PLANNING CONSULTATION RESPONSE

Application No	2026/0650
Proposal	Erection of building for vehicle maintenance (Use Class Sui Generis) and associated infrastructure including fuelling facilities; truck and plant wash facilities with surfacing works and formation of parking, following the demolition of existing buildings and structures.
Address	Wordsworth Business Park Whaley Road, Barugh, Barnsley, S75 1FJ
Date of Consultation Reply	18 th September 2026
Consultee	Highways DC

**Proposed Site Plan
External Finishes**

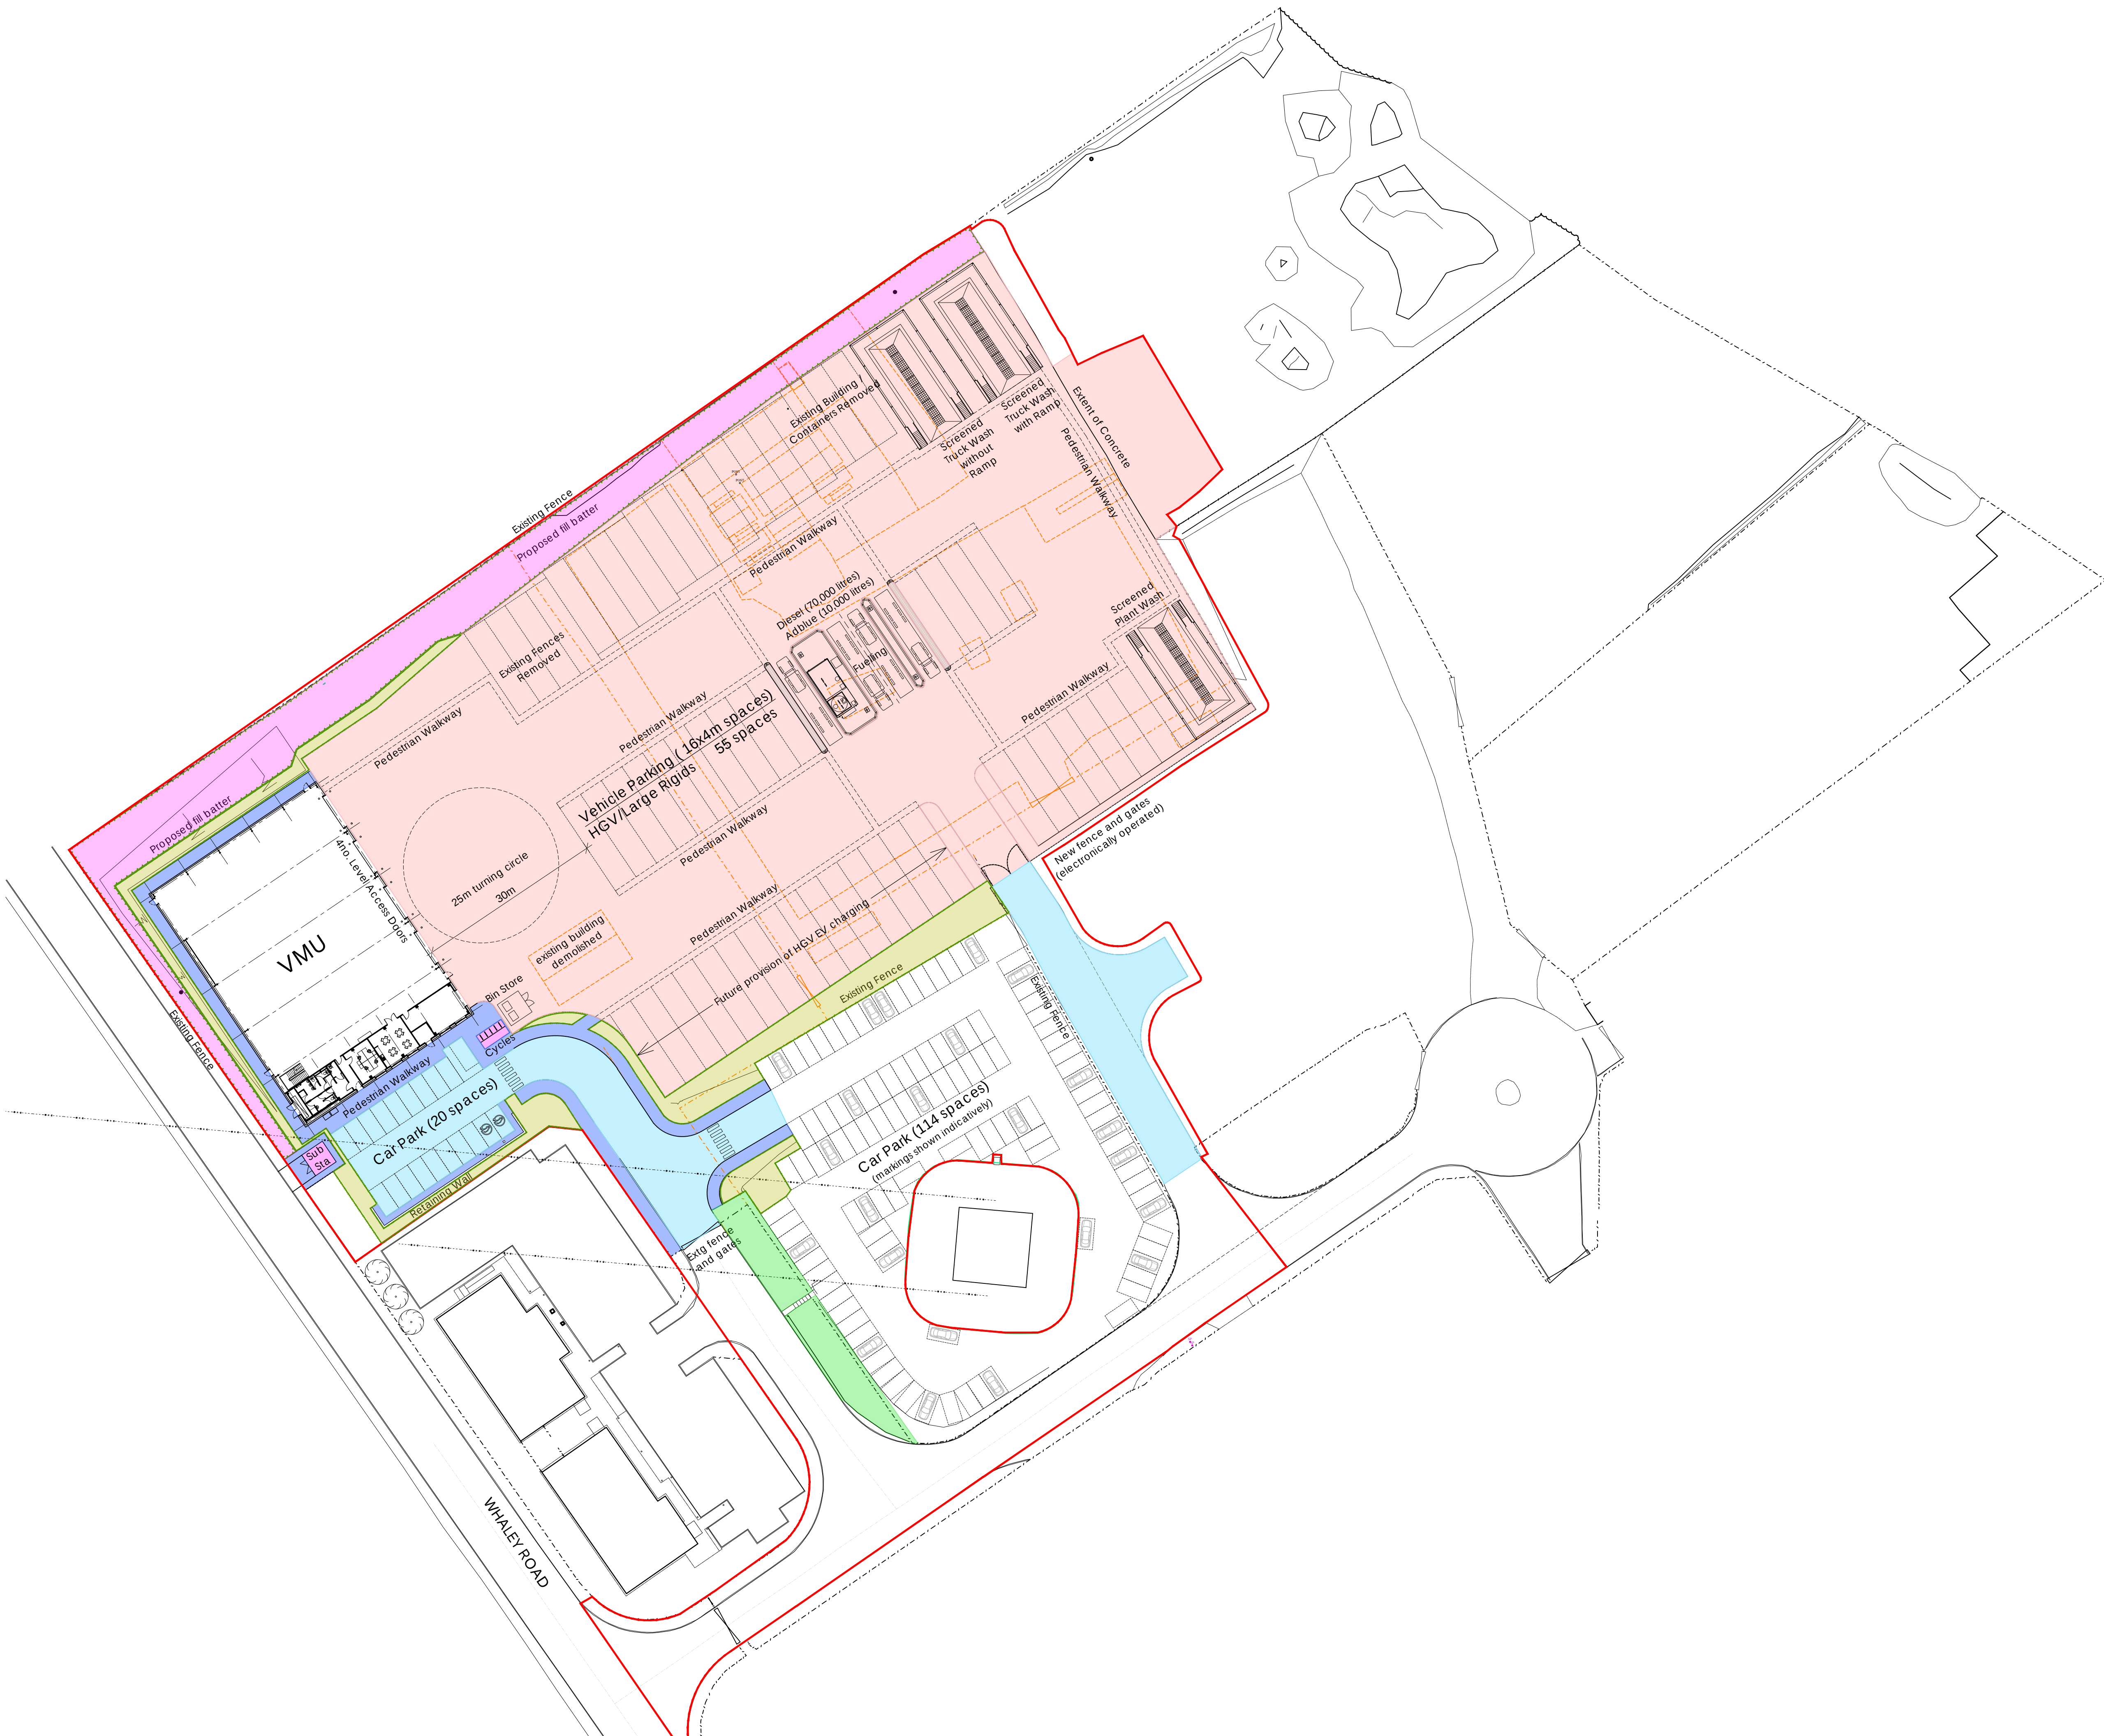
There are existing parking areas within the site which are to be formalised under the proposals in order to improve efficiency in the way that vehicles are parked. Parking survey results are included within the TS which show that the maximum car park occupancy would equate to 54%; the site therefore has adequate parking provision.

The proposed vehicle maintenance unit also includes ancillary office space for which an additional car parking area accommodating 20 vehicles is to be provided adjacent to the unit.

The proposed changes to the access roads within the site would provide a more formal arrangement and would, after the first 50m of the access road, effectively separate the routes used by cars and HGV's. No changes are proposed to the site access junction with Whaley Road.

Prior to the development being brought into use, all areas to be used by vehicles shall be laid out in accordance with the approved plan and must be properly consolidated and hard surfaced and drained into the site and subsequently maintained in good working order at all times thereafter for the lifetime of the development.

Proposed Cycle Shelter

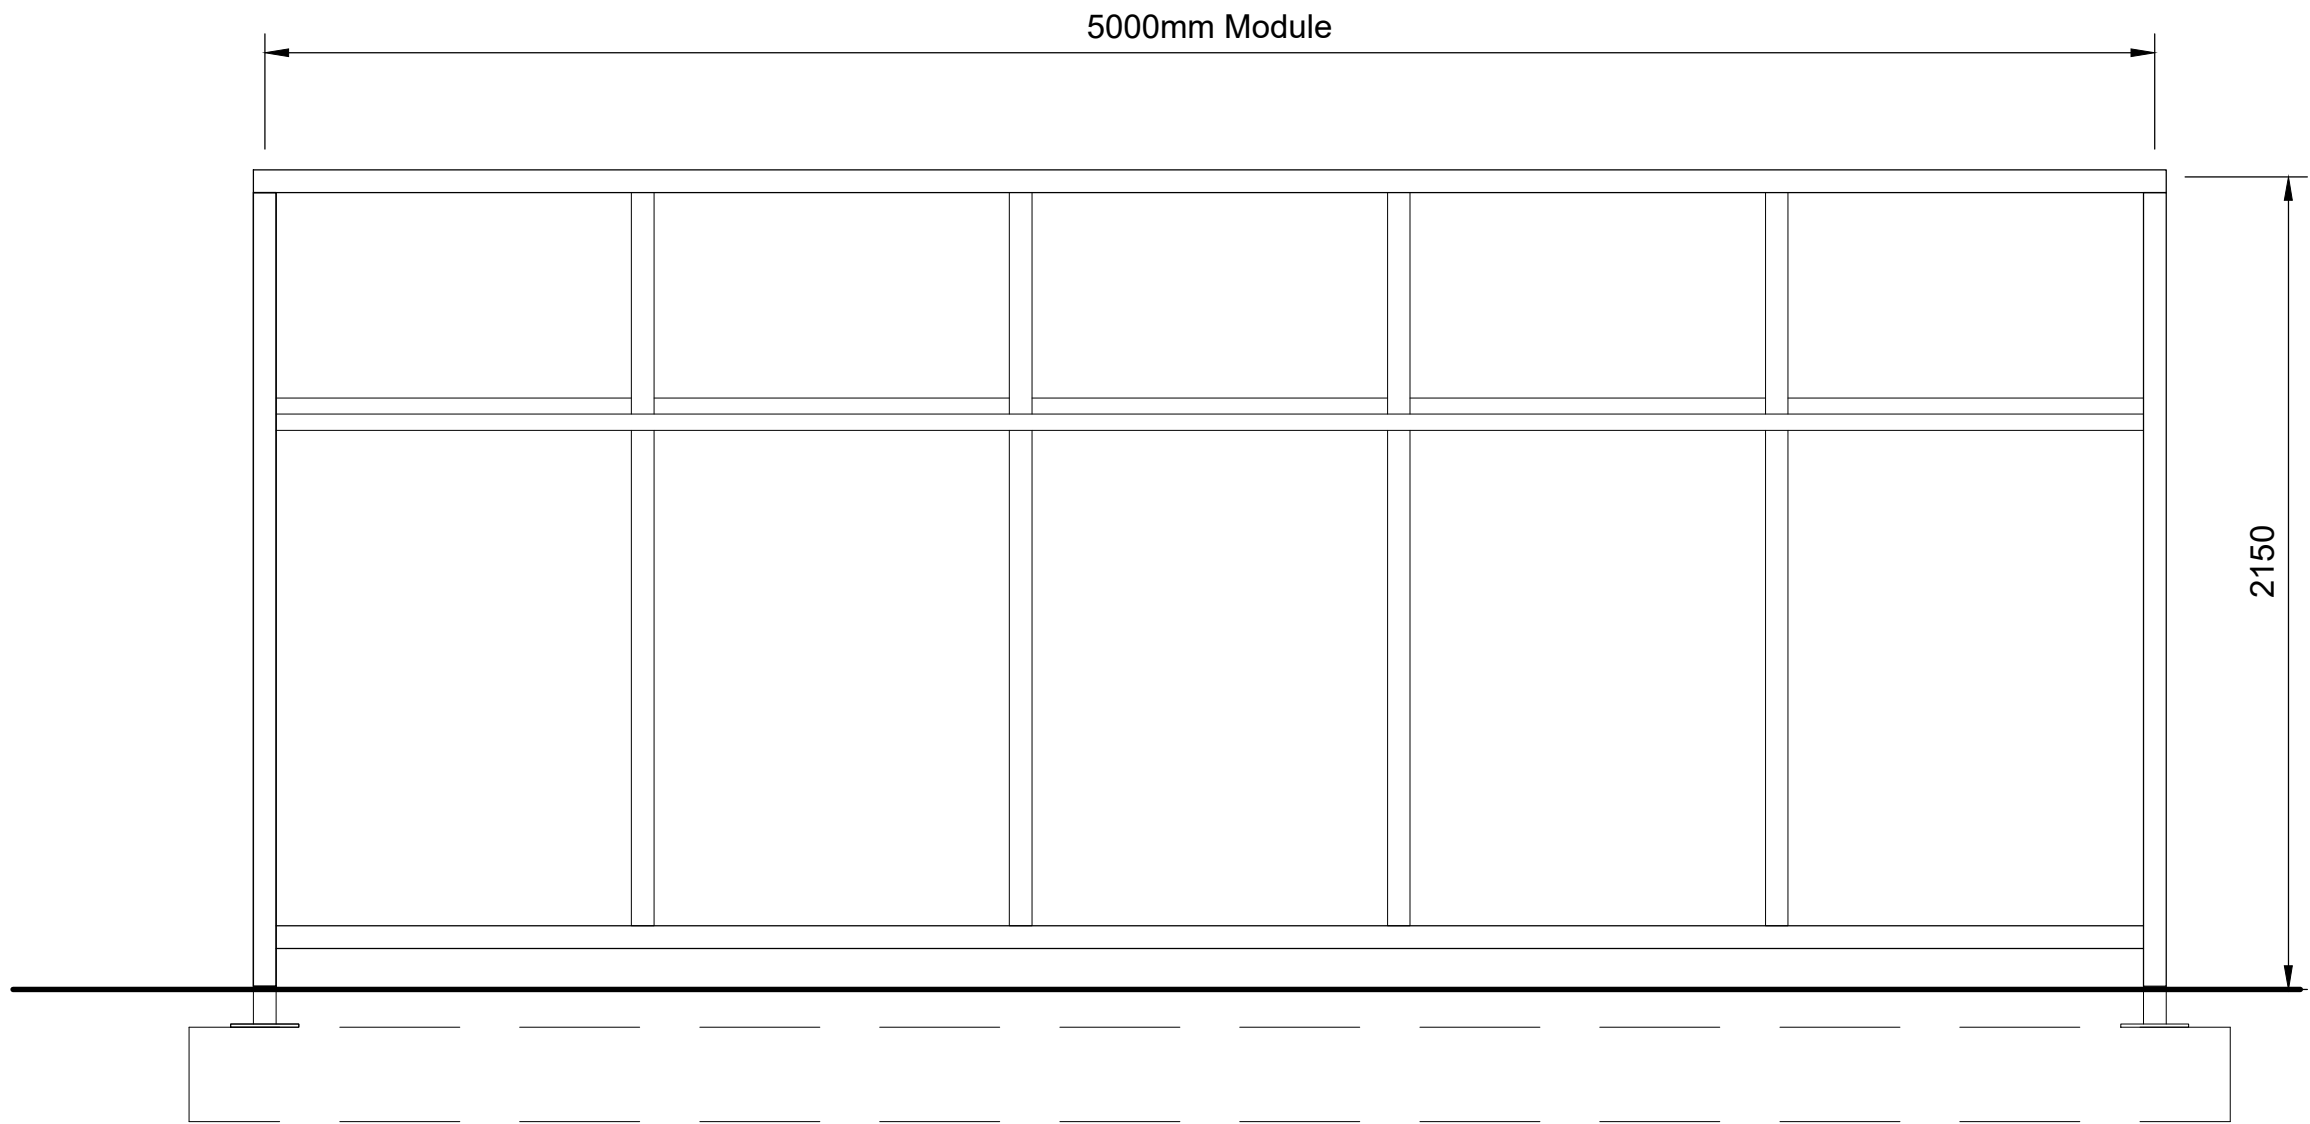
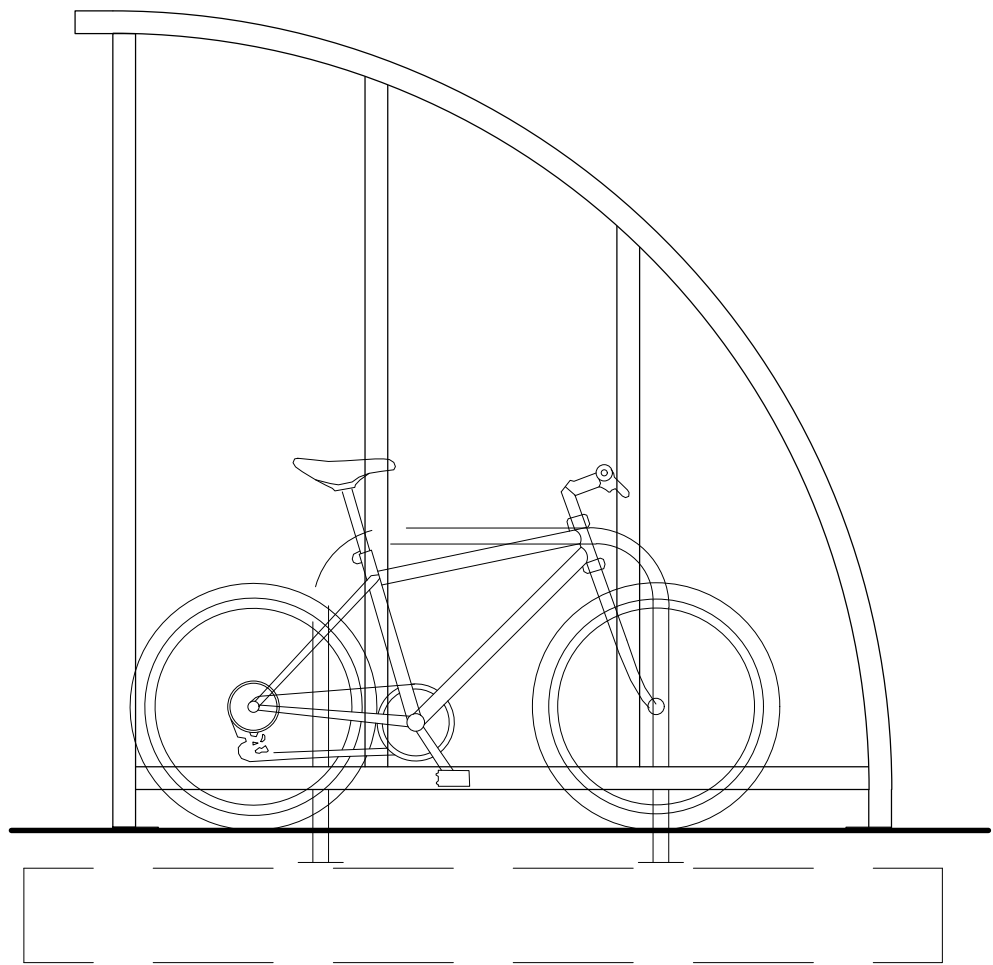
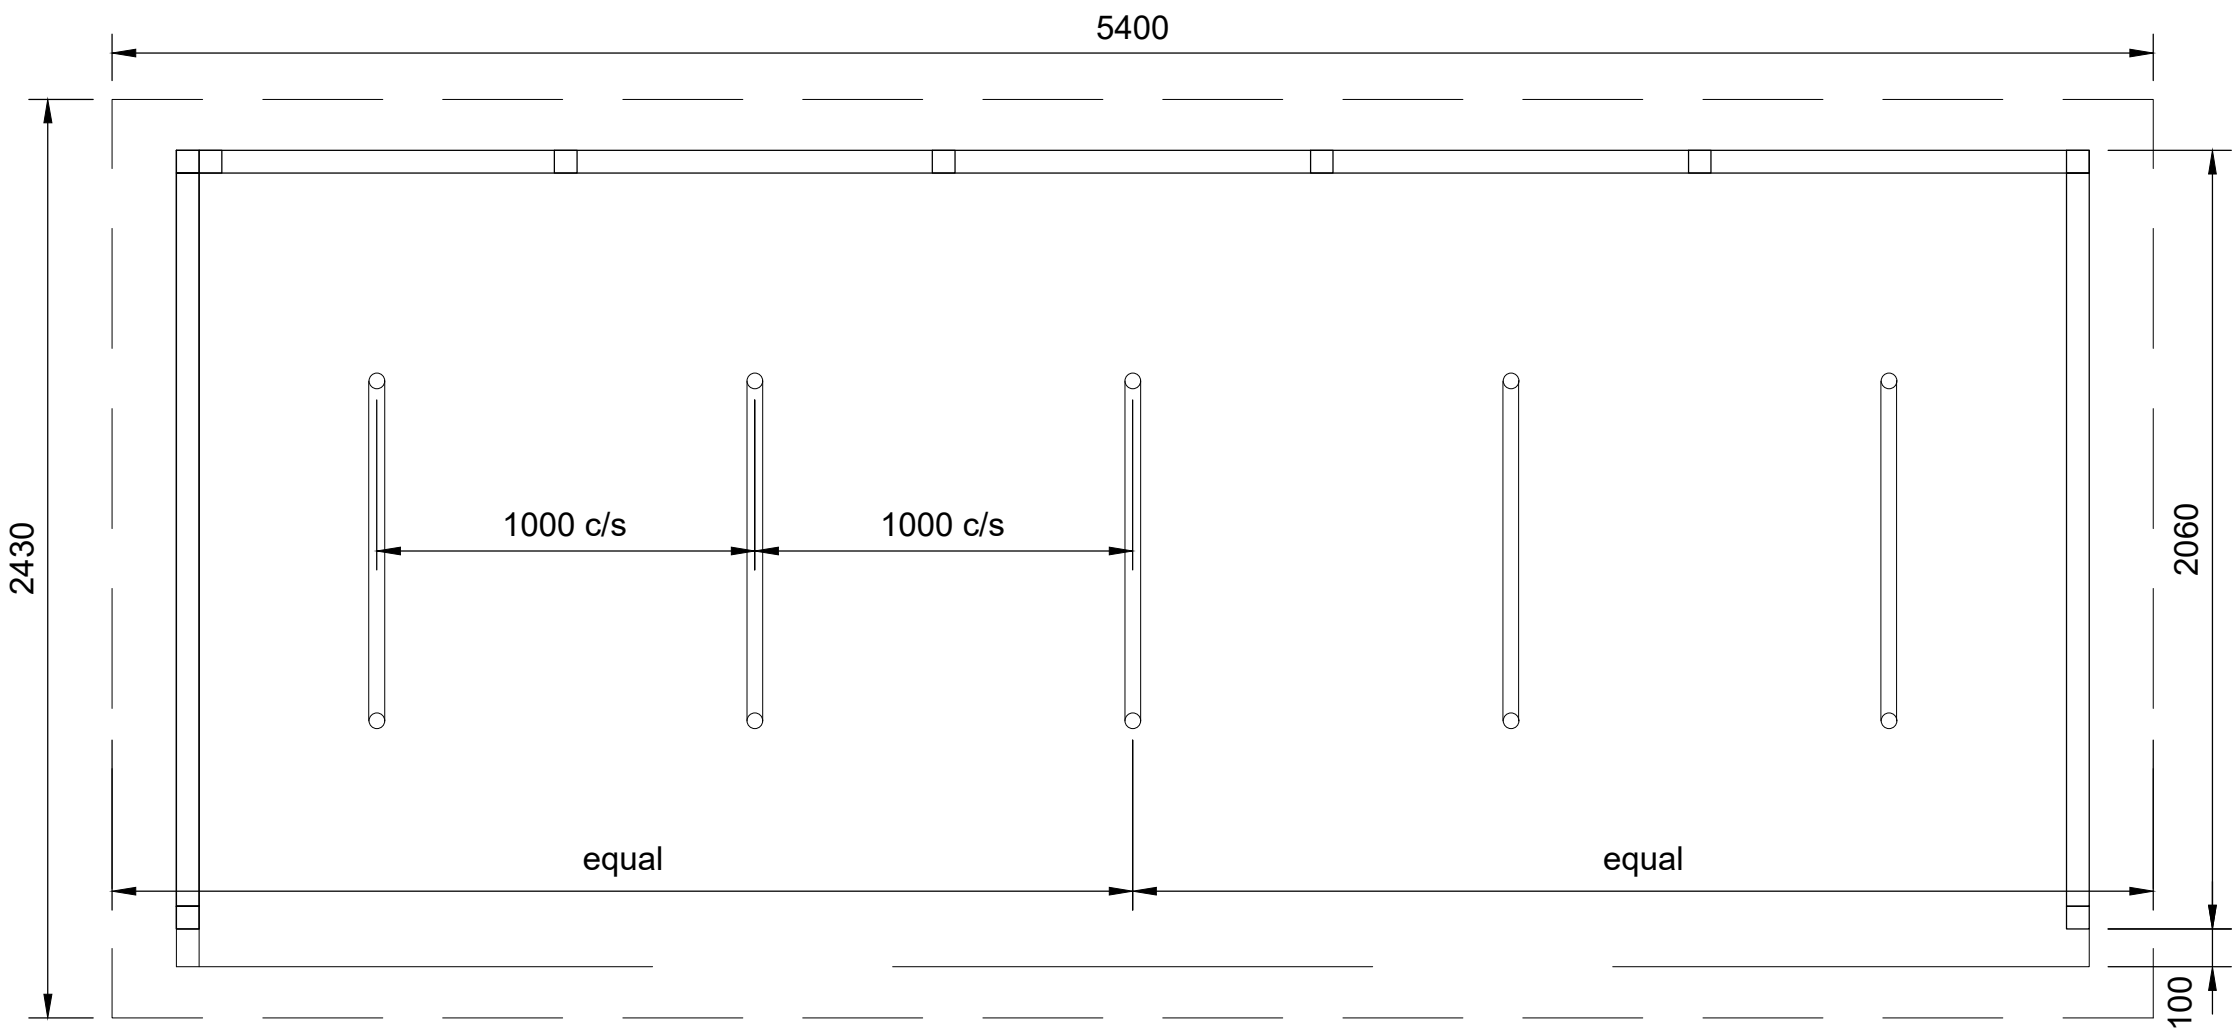
Prior to the development being brought into use, the scheme for the parking of bicycles as shown on the site layout plan shall be fully implemented and thereafter retained for this purpose.
